**Consultation Response from KC,
Lead Local Flood Authority**

2024/93026 land at, Manor Street, Newsome, Huddersfield, HD4 6NW

Discharge of details reserved by conditions 3 (materials), 5-9 (site contamination), 11 (external lighting), 12 (cycle parking), 13 (bin store), 14 (ecological design strategy), 15 (landscaping) and 16 (drainage) of previous permission 2022/90655 for erection of 10 student residential units with associated landscaping

Condition 16 – Drainage Details

20no. 1.0m x 0.5m x 0.39m Aquacell storage crates arranged in 4m x 2.5m grid and 0.4m deep to provide 4m³ of attenuation.

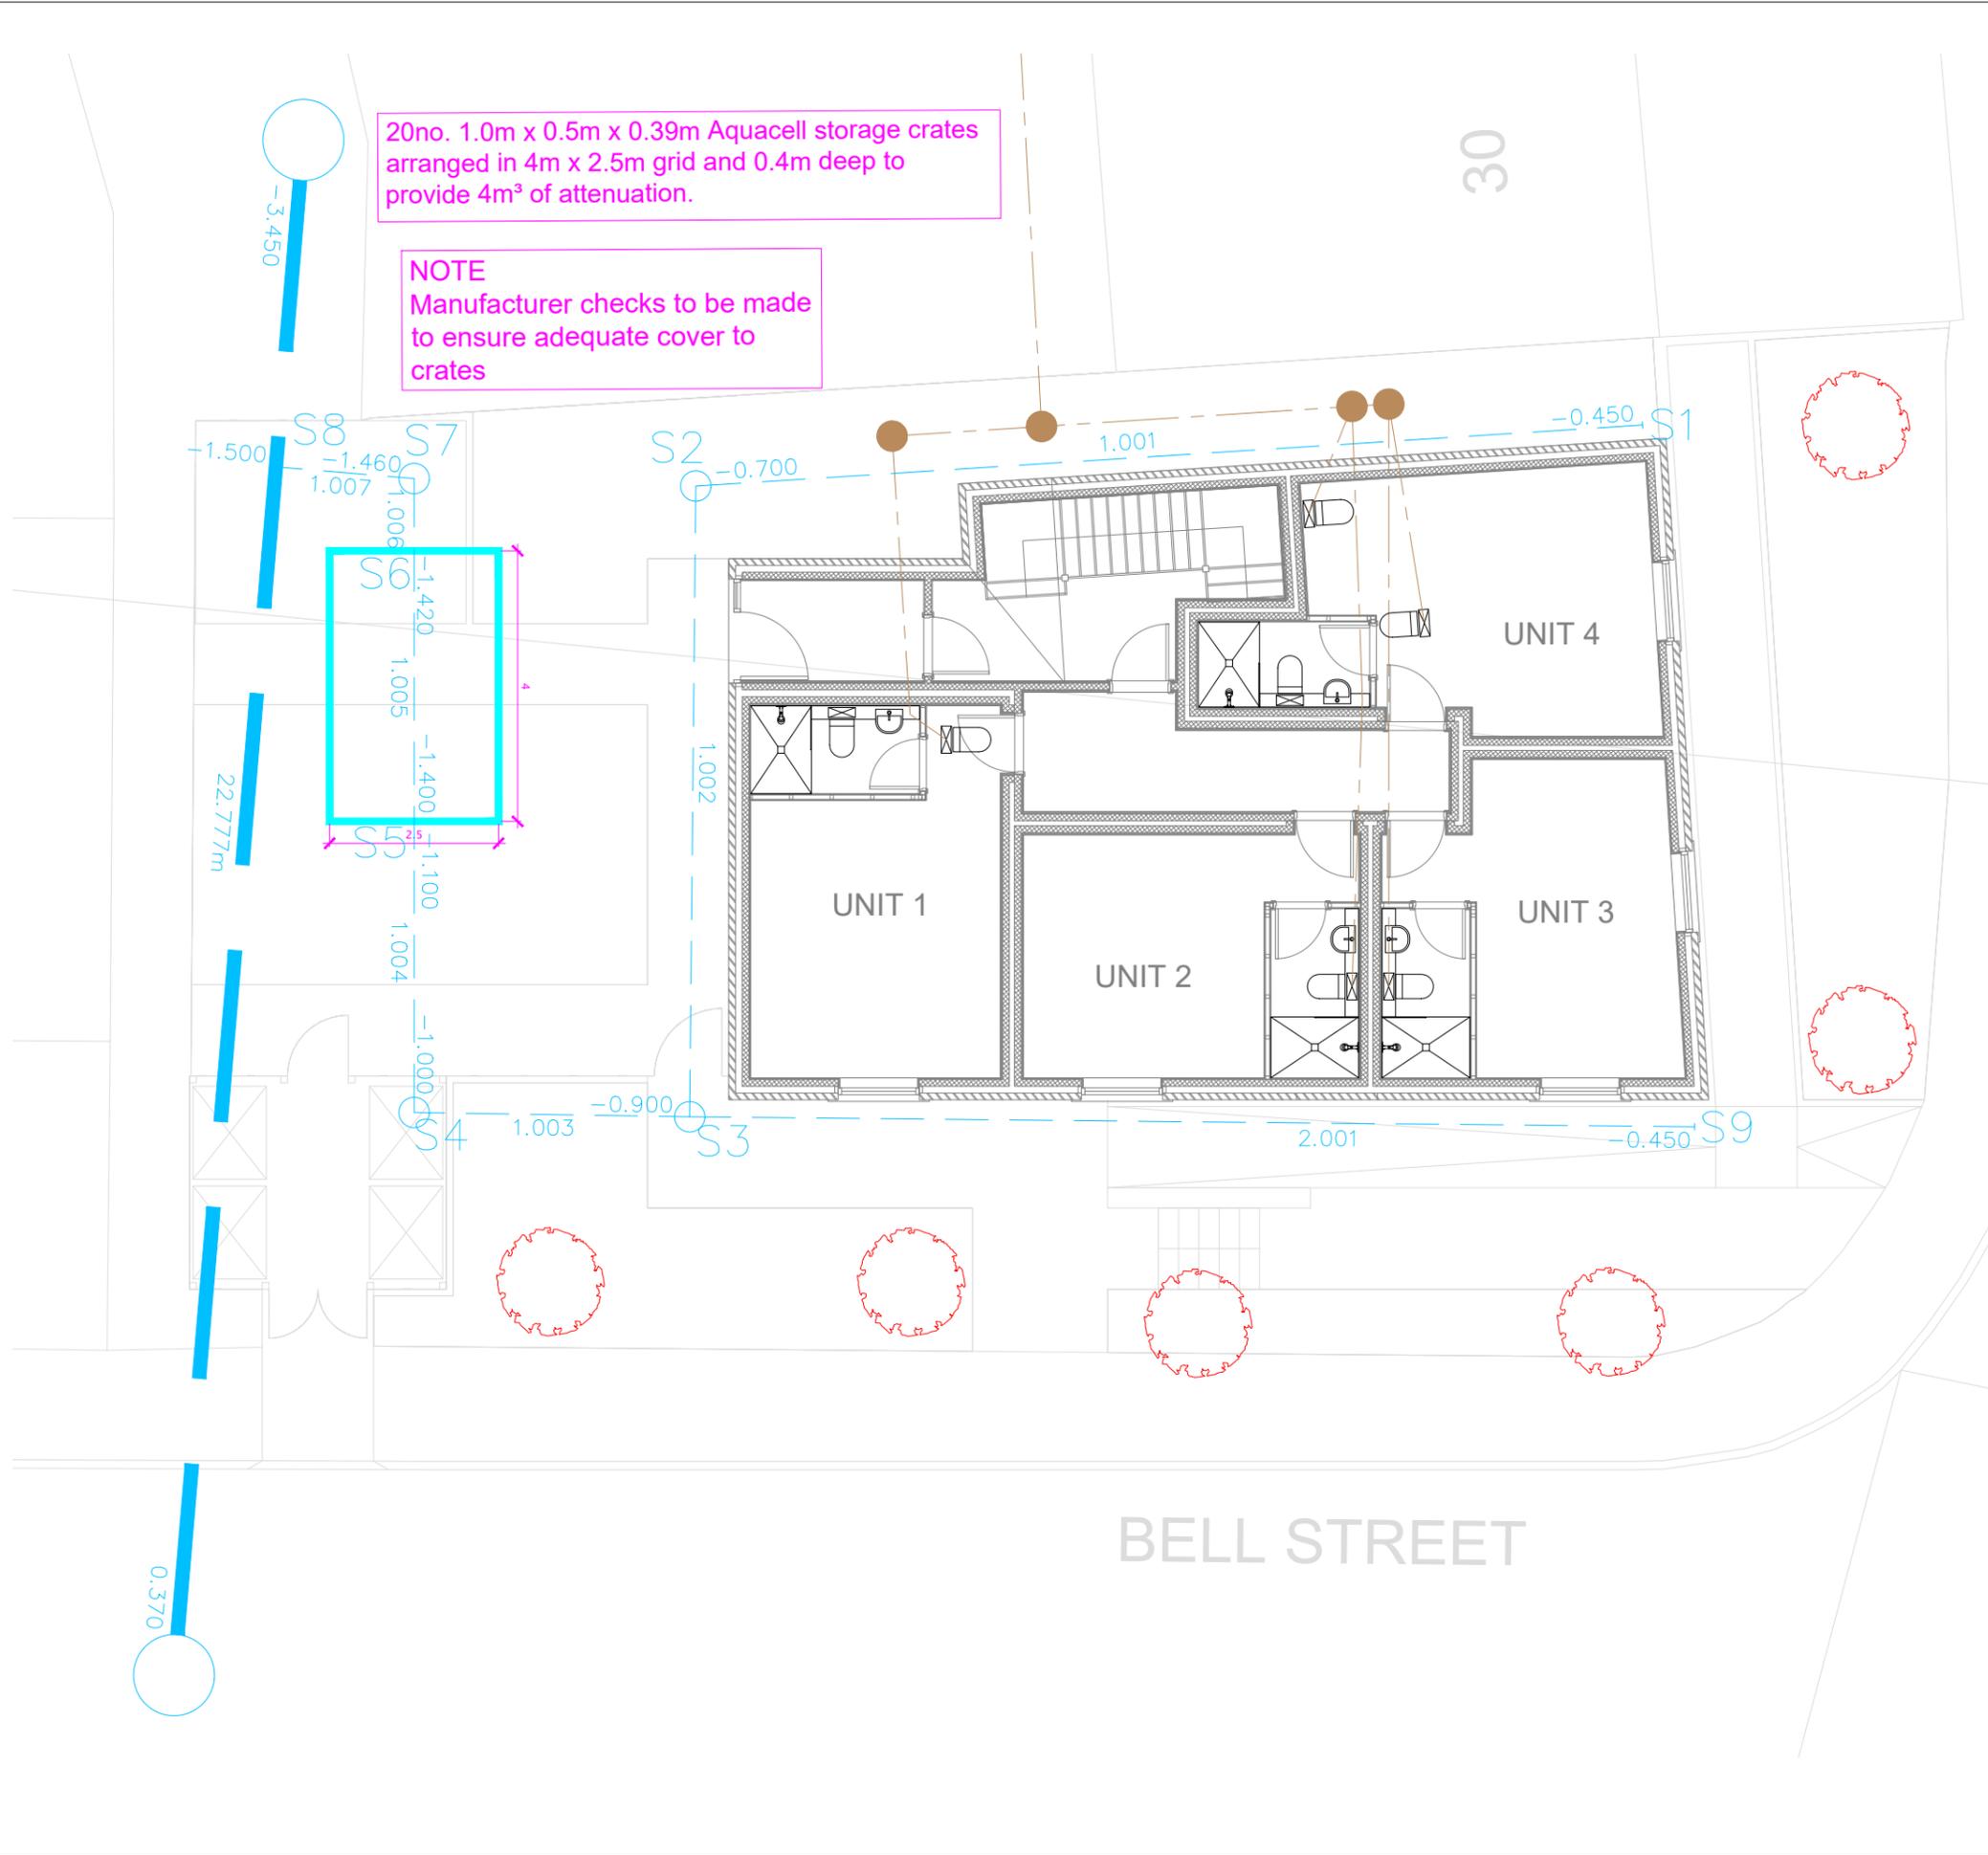
An r-value of 0.28-3.0 should be used for Newsome, not 4.0 in the submitted hydraulic calculations. Standard volumetric coefficients for both summer and winter storms should be used and evidenced.

The exact location of the watercourse should be ascertained, and buildings and other structures should be a minimum 2.5m away from buildings and other infrastructure and protected from dead loading.

An exact level of the connection to the watercourse is required. This can be interpolated from invert levels of up and downstream manholes.

Full details of the tank, plan and cross section is required include special measures for sediment control and inspections.

A drawing should be included that demonstrates the area of positive hard standing contributes to surface run off.

A discharge rate of 3l/s will be allowed on this greenfield site. All drawings should show this in the notes.
